From: Matthew
To: [Mark Adams](#); [Planning](#); [Caroline Ford](#)
Cc: [Peter Wright](#); [Lindsey Anderson-Gear](#); [Verena Breed](#)
Subject: Comments on Application 18/00484/OUT
Date: 13 April 2018 16:53:37

Land North And Adjoining Home Farm Banbury Road B4100 Caversfield

Fig 5.1 - Access and Movement Parameter Plan

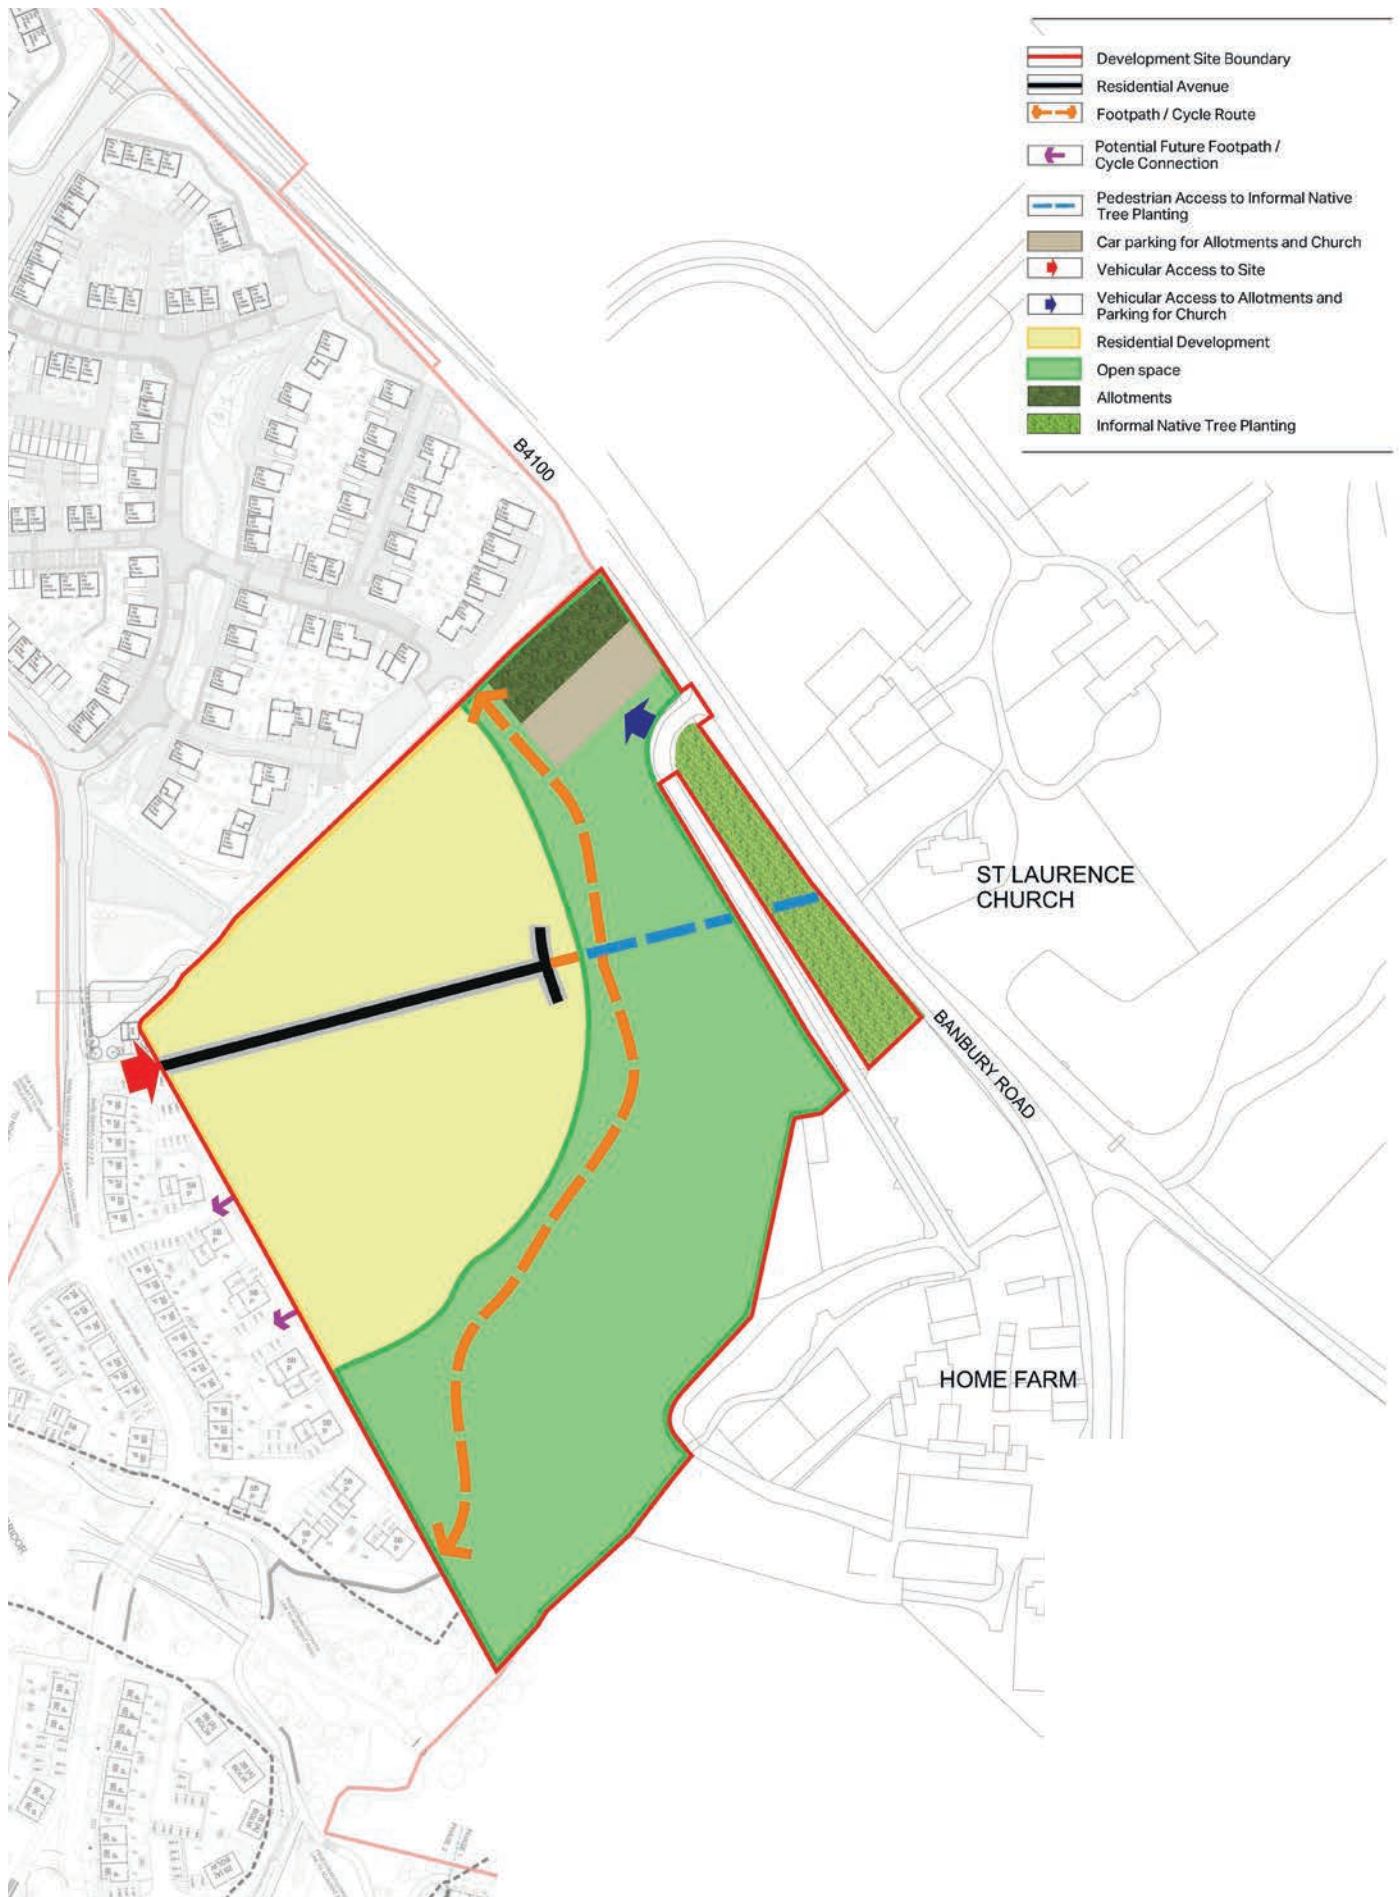
However, although the above provisions are included in the Illustrative Master Plan on the website, we note that the Access and Movement Parameter Plan does not include the road crossing or the pedestrian access. This omission from the proposal concerns us; we would ask that the inclusion of these be made a condition of granting outline planning permission. Without them the development would have only a detrimental effect on the church and the local community through increased traffic, reduced access and the loss of open green space.
